Re: Project #PR-2019-002496 for Southeast Corner of Alameda Blvd. NE & Barstow Street NE

Vineyard Estates Neighborhood Association is aware of the upcoming [re]hearing for an application by Consensus Planning for a site plan on behalf of Philip Lindborg and the Mantoni

Family Trust for development of 93 apartments on the southeast corner of Barstow Street NE and Alameda Blvd. NE on August 14, 2019. It is our continued understanding that the property zoning is MX-L under the current IDO and this application is a permissive use of the property. Additionally, it

1. ANY BUILDING MOUNTED SIGNAGE IS TO BE ACHIEVED THROUGH A SEPERATE BUILDING PERMIT IN ACCORDANCE WITH THE UNDERLYING MX-L ZONING

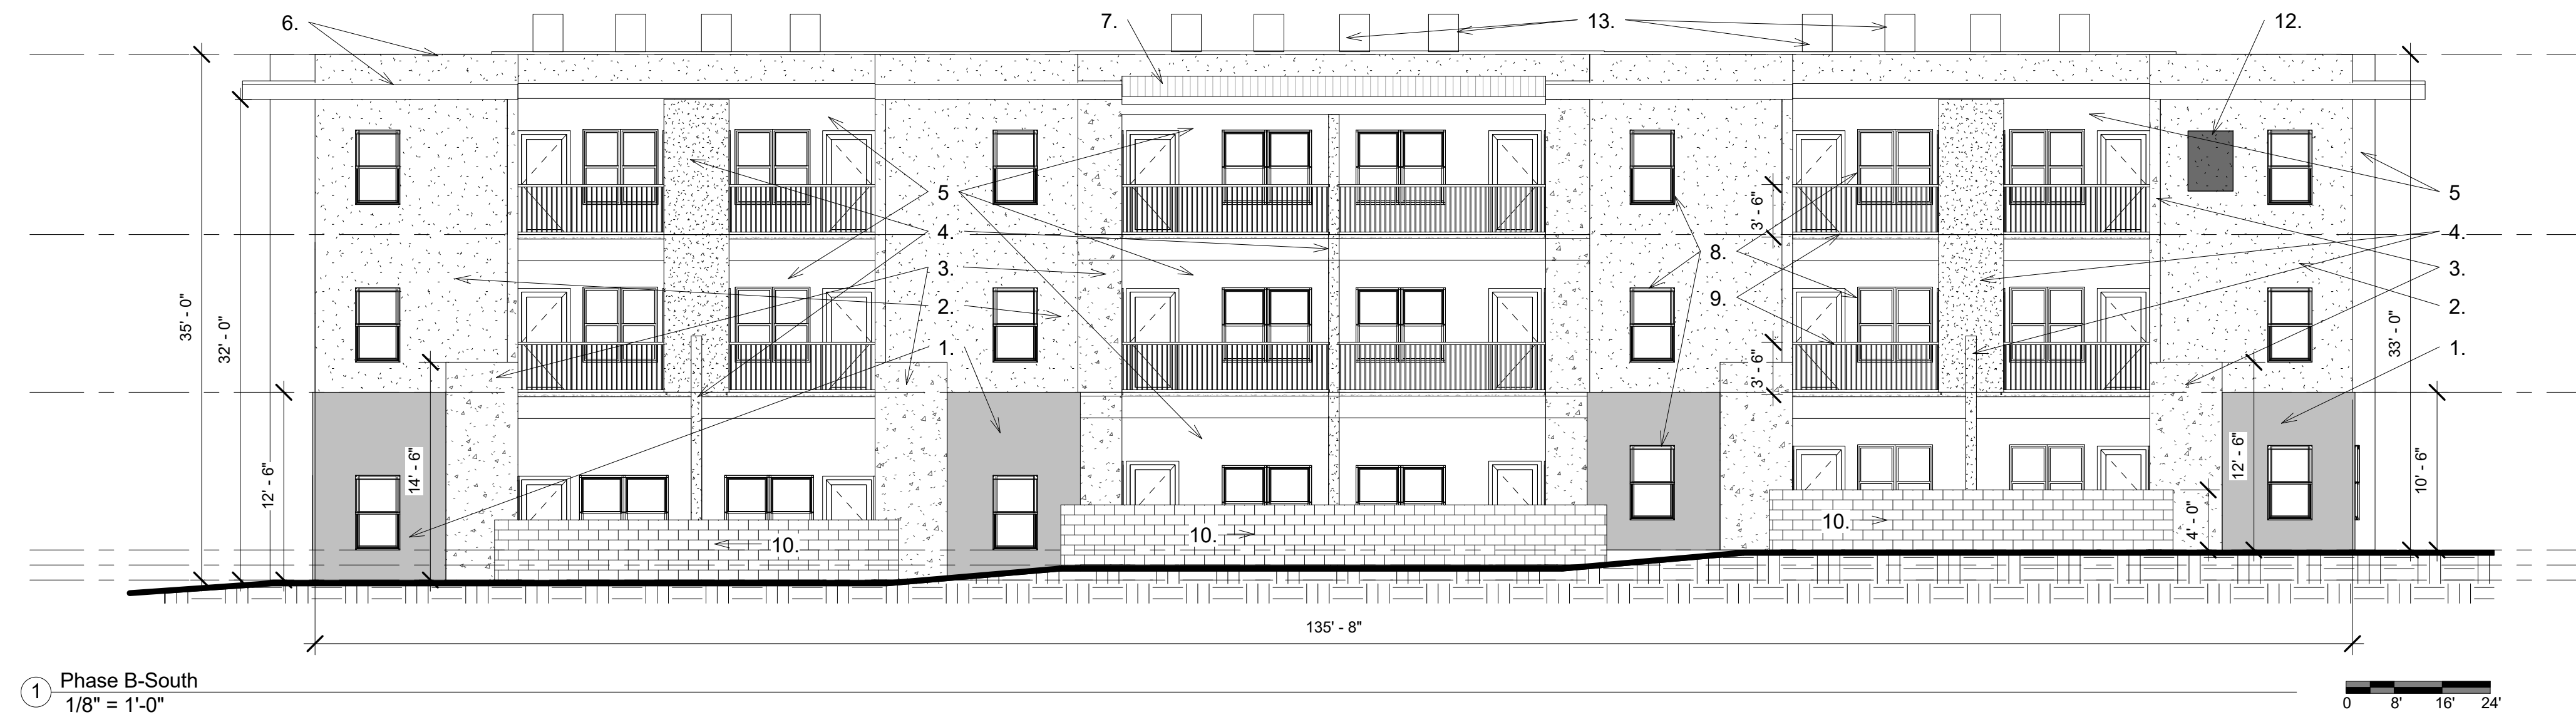
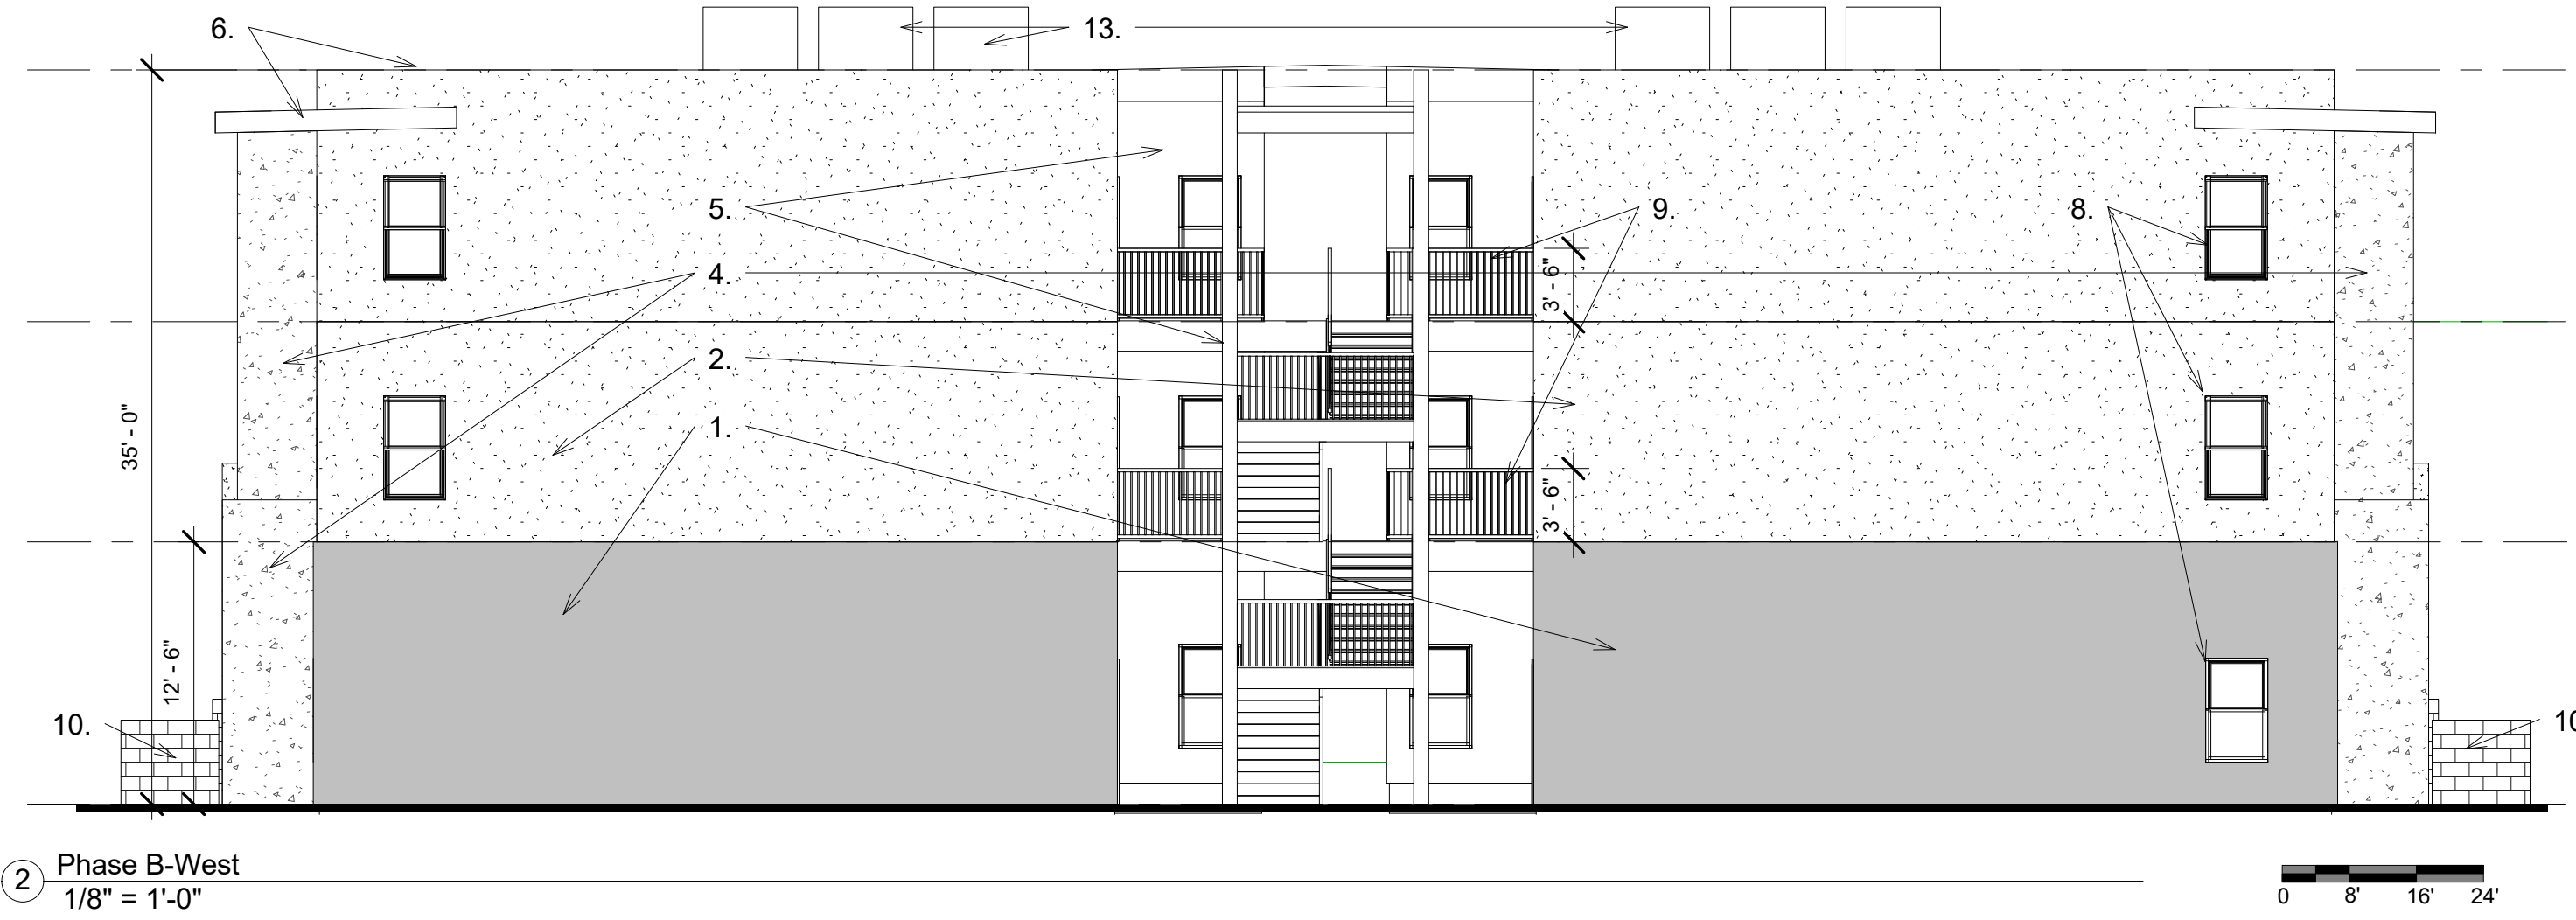
- 4) ***Urban Design Style:*** The design style of a 3-story, flat roof, brightly colored building (medium-grey, tan, red-orange, off-white, orange-yellow per Jeebs & Zuzu, Inc. June 2018

provided documents) does not blend in with the surrounding earth tone homes (many of which have covenants clarifying appropriate paint color choices of which most of these colors would not be allowed) and gabled roofs of Tierra Morena (south-affected neighborhood), Pico la Cueva Place (north-affected neighborhood), and Tierra Montana Place NE (west-affected neighborhood). Using an example of an Italian design in a southwest style neighborhood, again does not blend in or enhance surrounding home values. Use of black chain-link fencing as the security surround also does not fit with the tasteful design required by the surrounding neighborhoods' covenants of stuccoed walls or wrought-iron gates/fencing to contain yards and pools. Additionally, there appears to be an inadequate amount of landscaped "green/open space" relative to the size of the property and amount of black asphalt parking surrounding the buildings.
